5. Landscape & Visual Steeple Renewables Project

November 2025

**FIELDS FOR
FARMING**

VIEWPOINT 6B

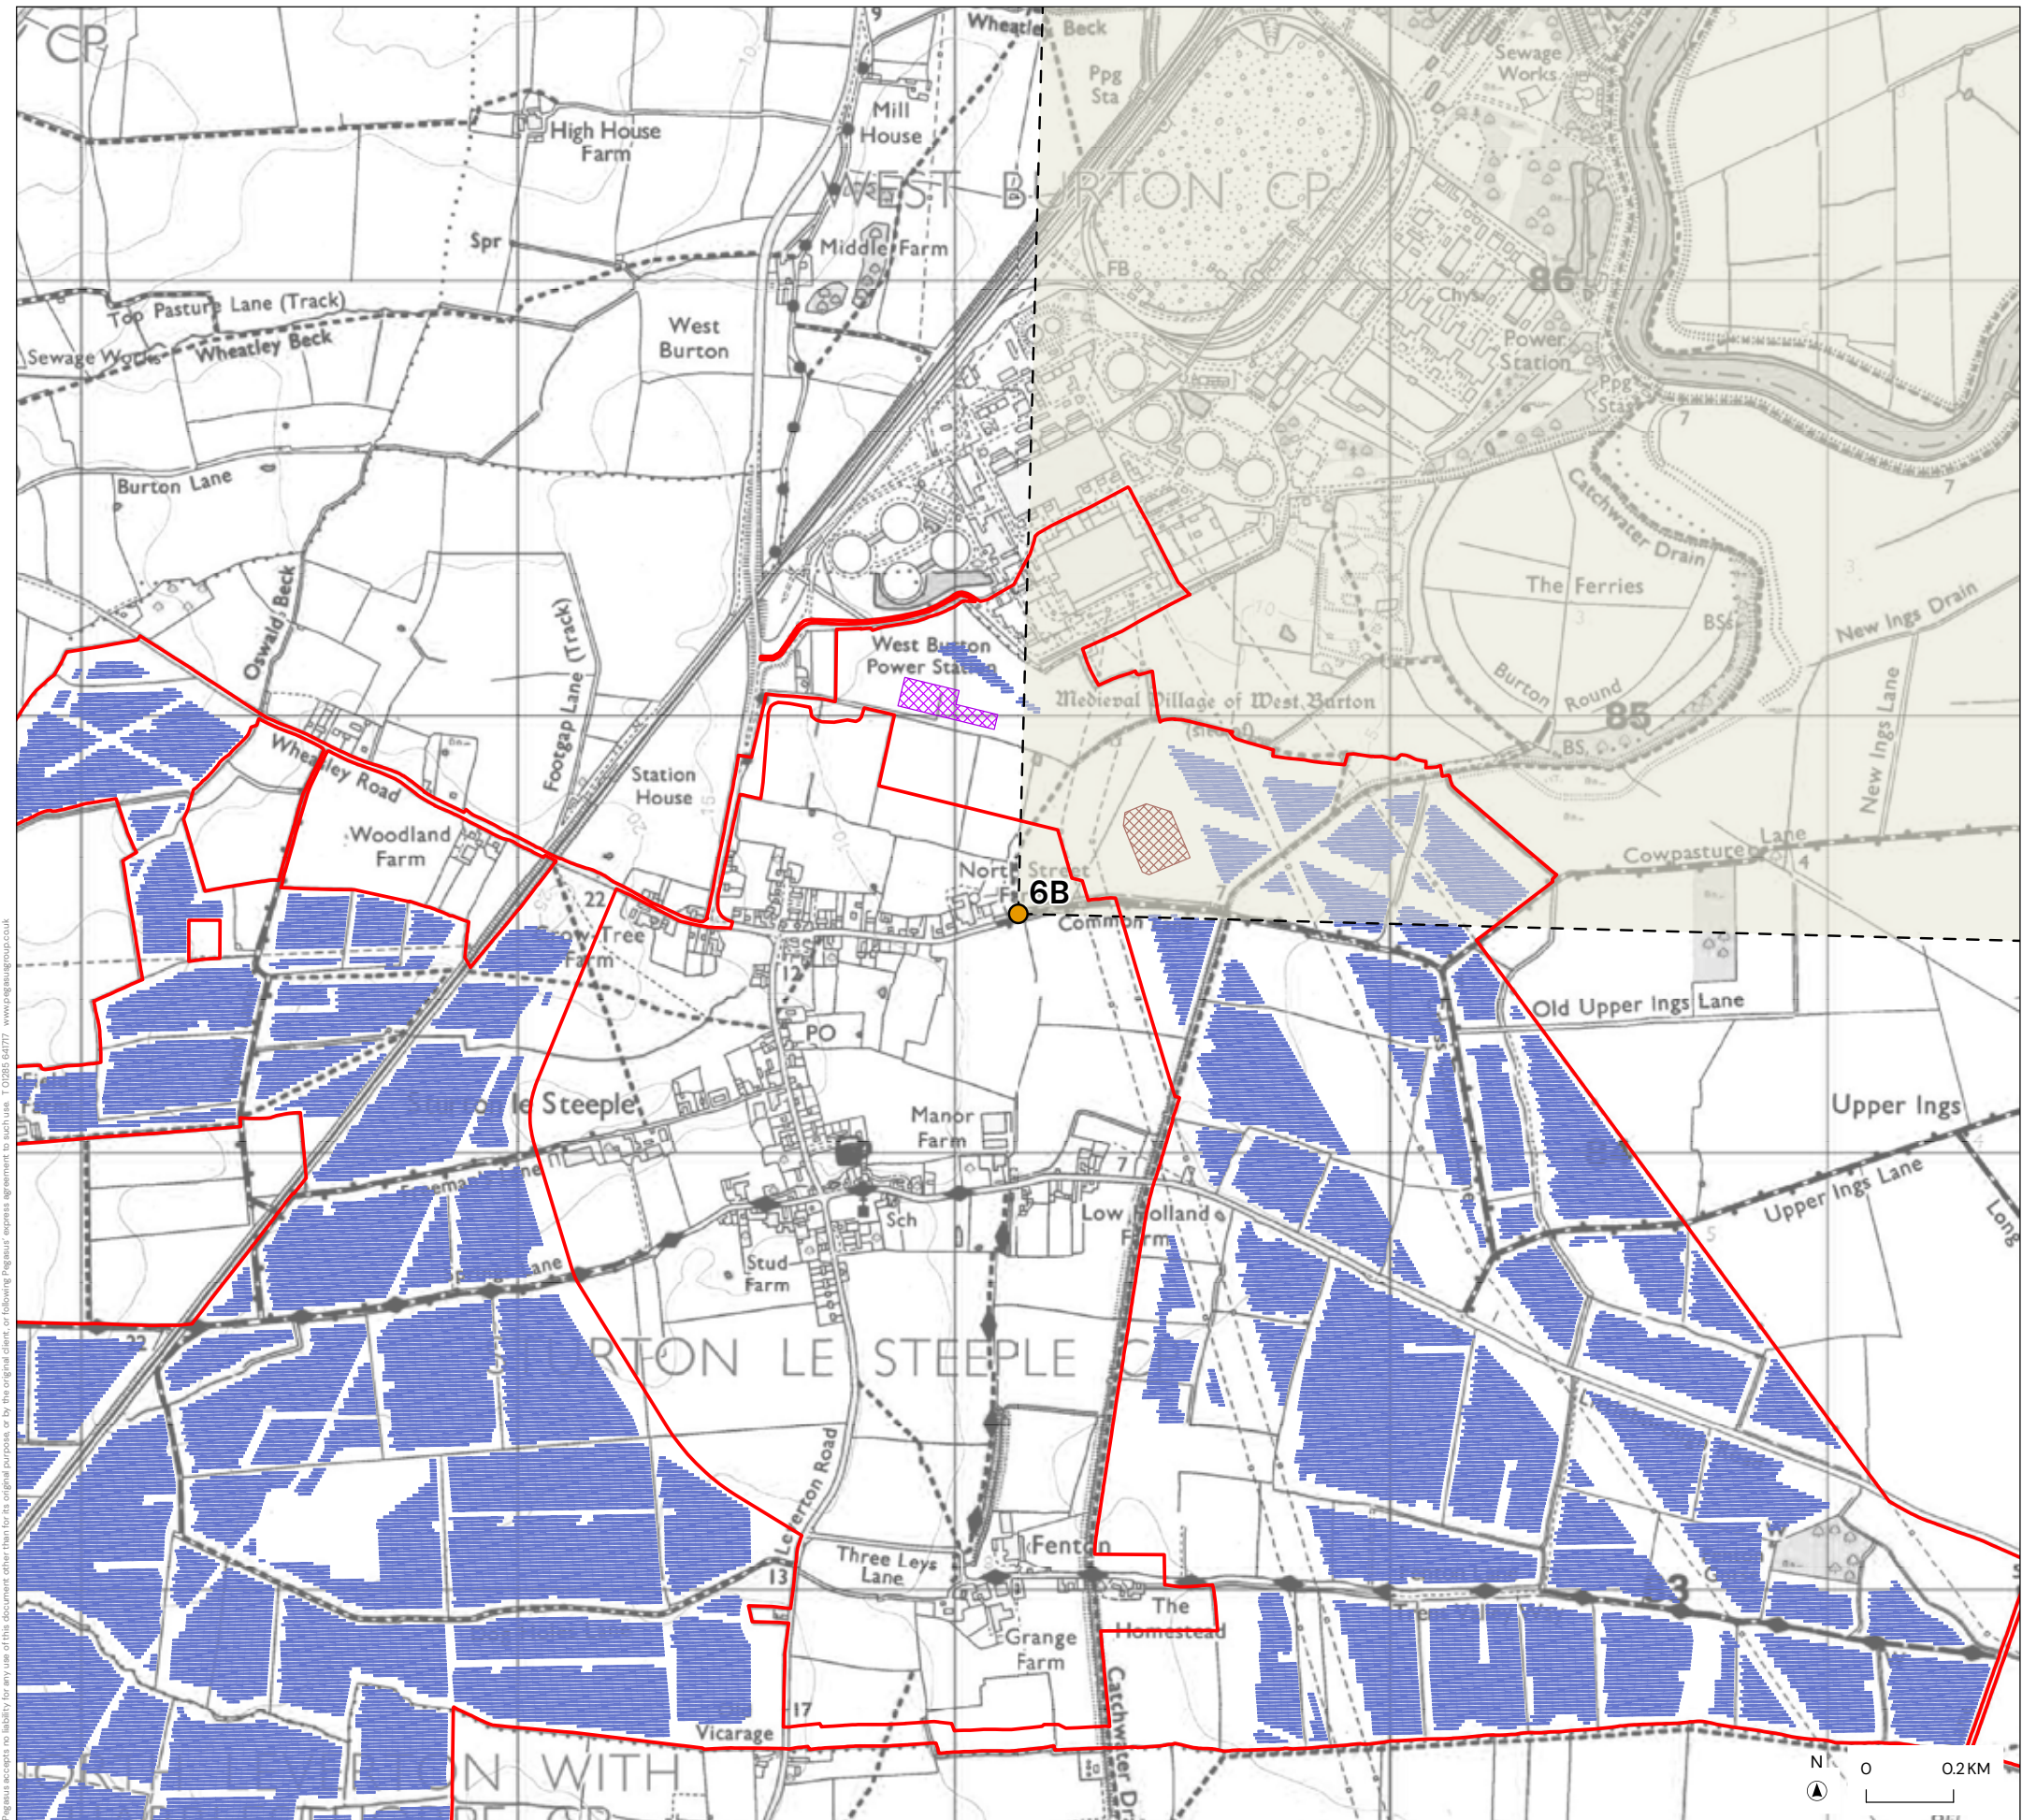
VP 6a, 6b, 12, 13a, 13b, 14b all show West Burton Cooling Towers in the backdrop, and continue to do so through out, these towers will be gone by 2026/2027. By turning 180 degrees and taking photographs would have given a far better reflection of the area being affected by the development and would have shown how open and rural the landscape and views actually are.
